DARLINGTON PUBLIC SCHOOL
 SSD - 9914 ARCHITECTURAL DESIGN UPDATE

RESPONSE TO GANSW

GOLDEN GROVE STREET, DARLINGTON, SYDNEY
 Department of Education

fjmt studio architecture interiors urban landscape
 28 SEPTEMBER 2020 REV 01

14 Perspective Cutaway FT07
NTS

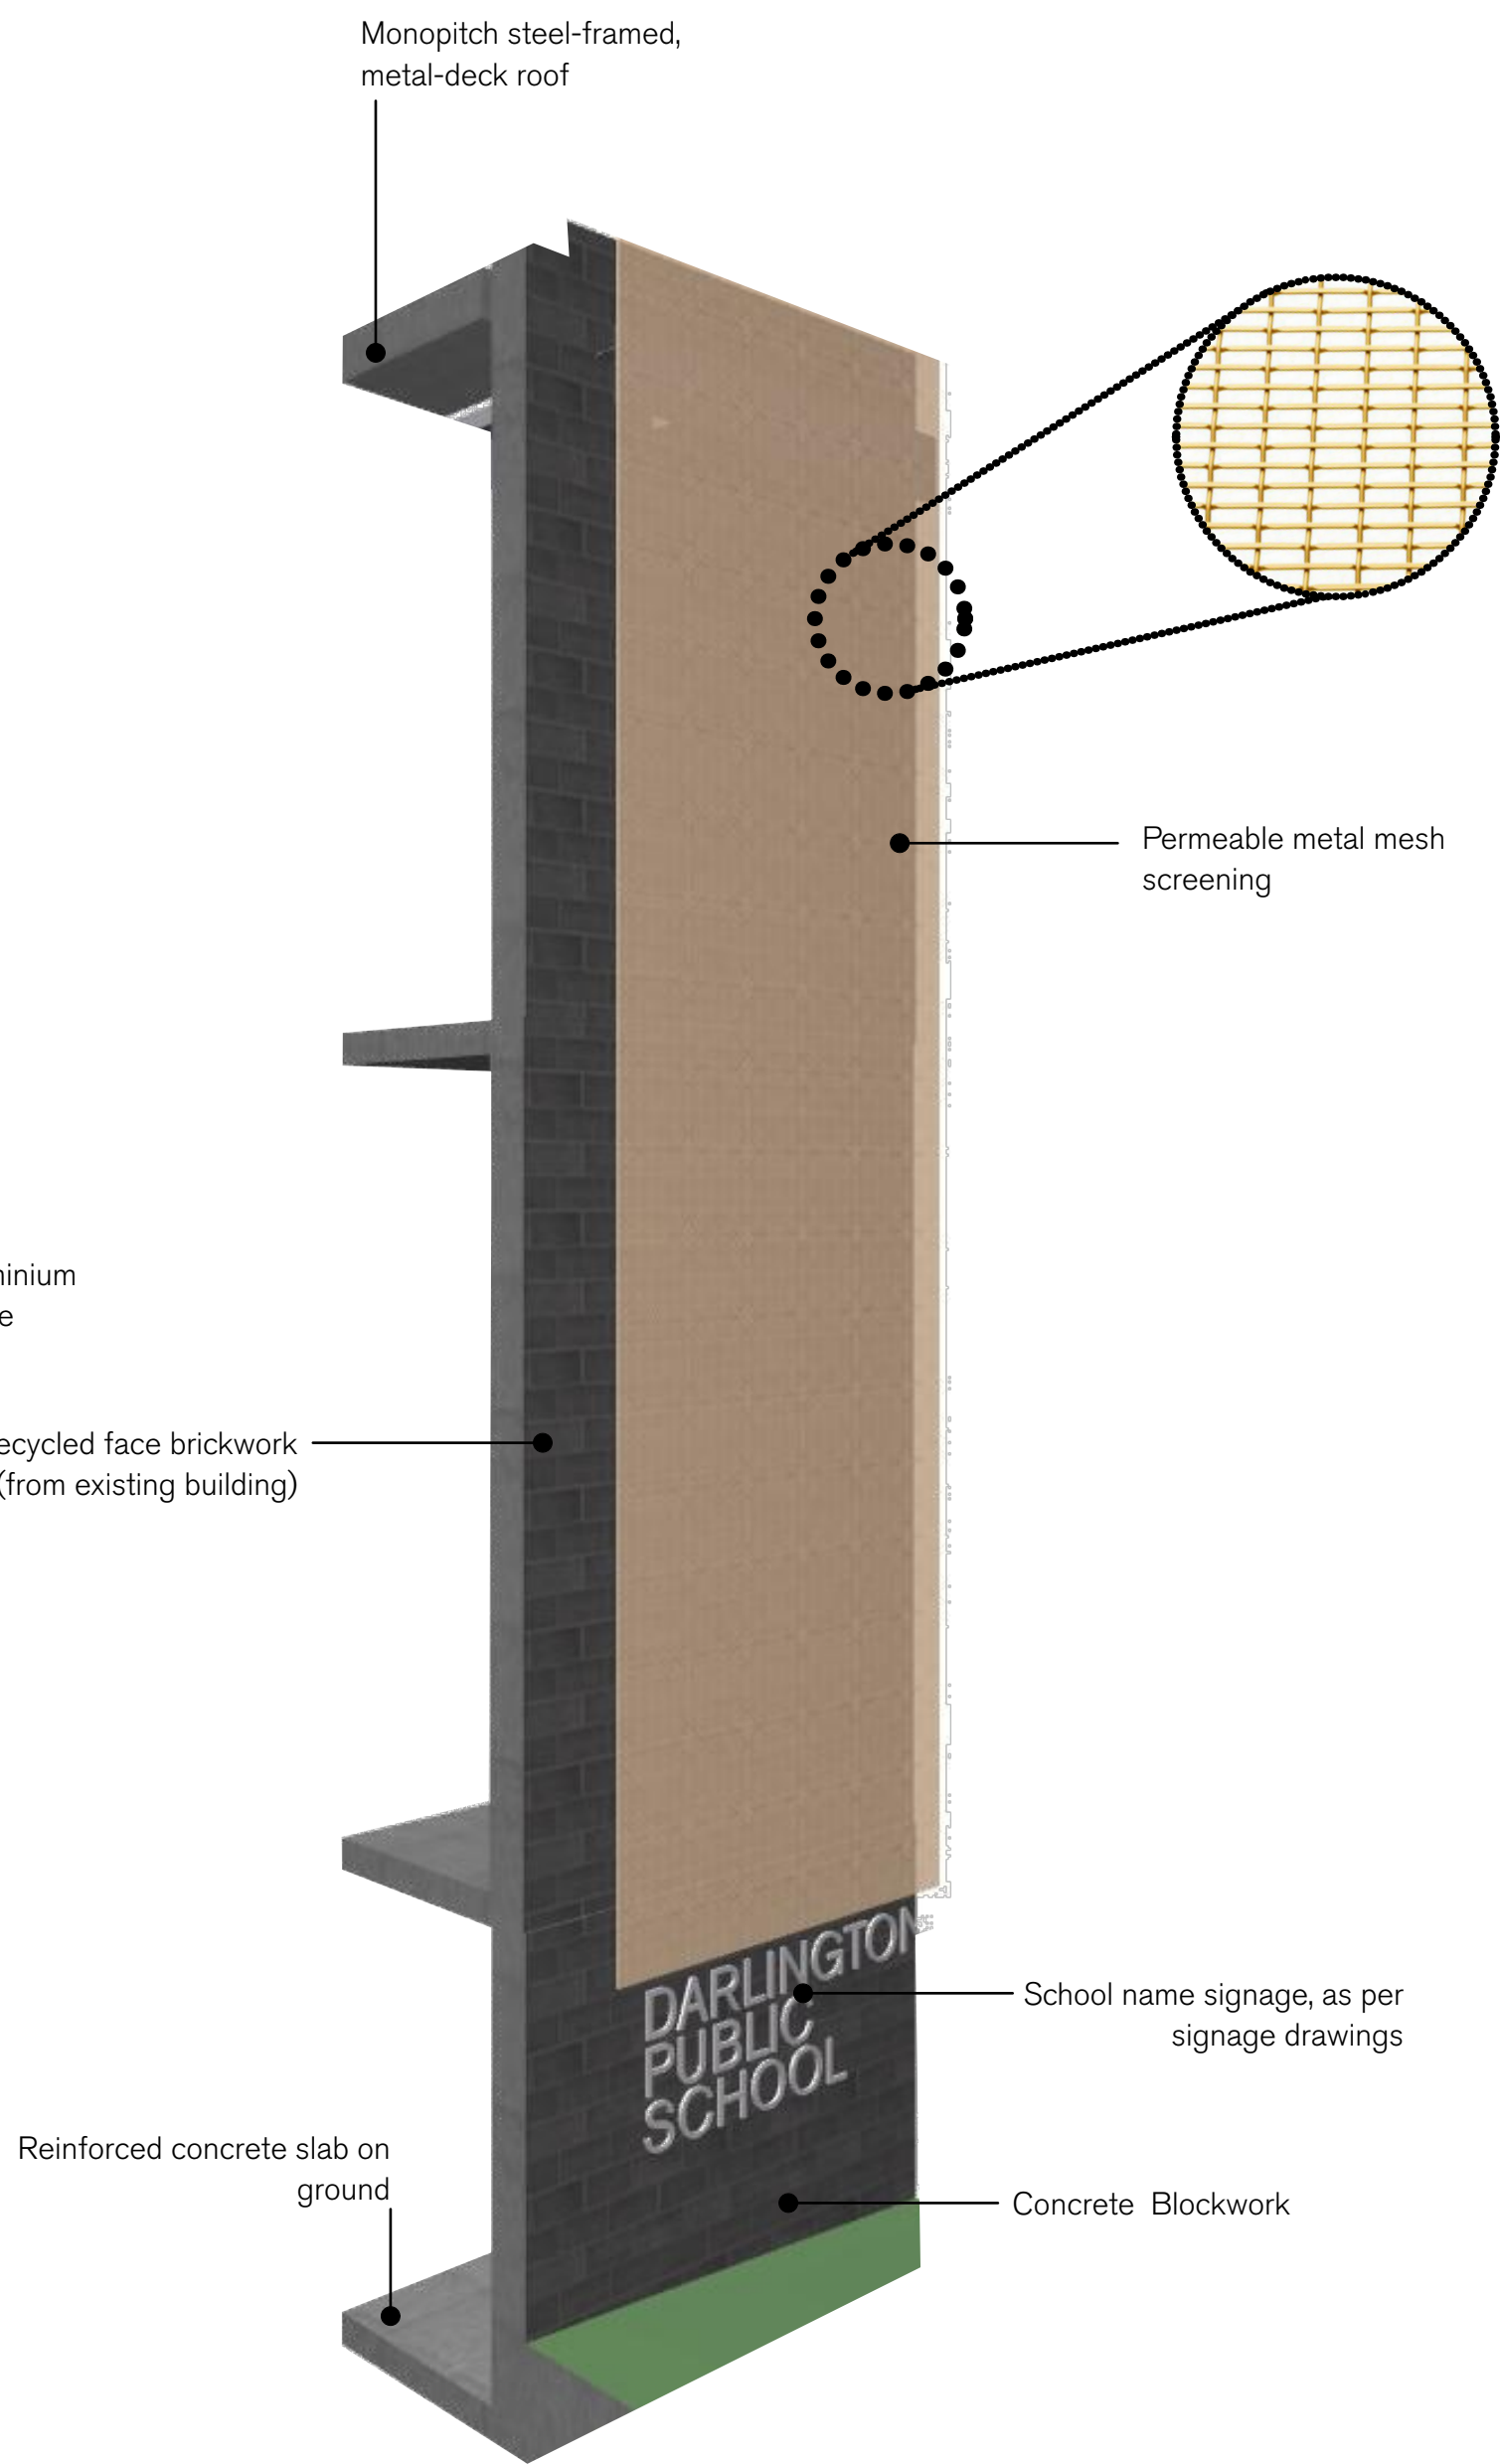
Item	Government Architect Initial Response to SSDA, 09 July 2020	fjmt Response	Page
1	The proposed buildings present large blank facades to both Golden Grove and Abercrombie streets. Articulation of the facades, further definition of openings and detailing of materials to positively address the public domain is requested.	<p>The facades facing Abercrombie Street have been further developed and articulation to the western and southern facades has been incorporated.</p> <p>The glazing and brickwork to the southern facade of the hall building has been detailed to provide a finer grain response to the streetscape.</p> <p>The previous single large window into the south facade of the communal hall has been divided into 5 smaller windows. These are set into a recessed brick facade with large splayed sills and clearly defined brick blades between the glazing elements.</p> <p>This creates a more interesting street frontage, responding to the local context and a more structurally efficient result.</p> <p>The openings along the low-level brick facade facing Golden Grove street have also been refined.</p>	Refer Section 1.0, pages 5-10.
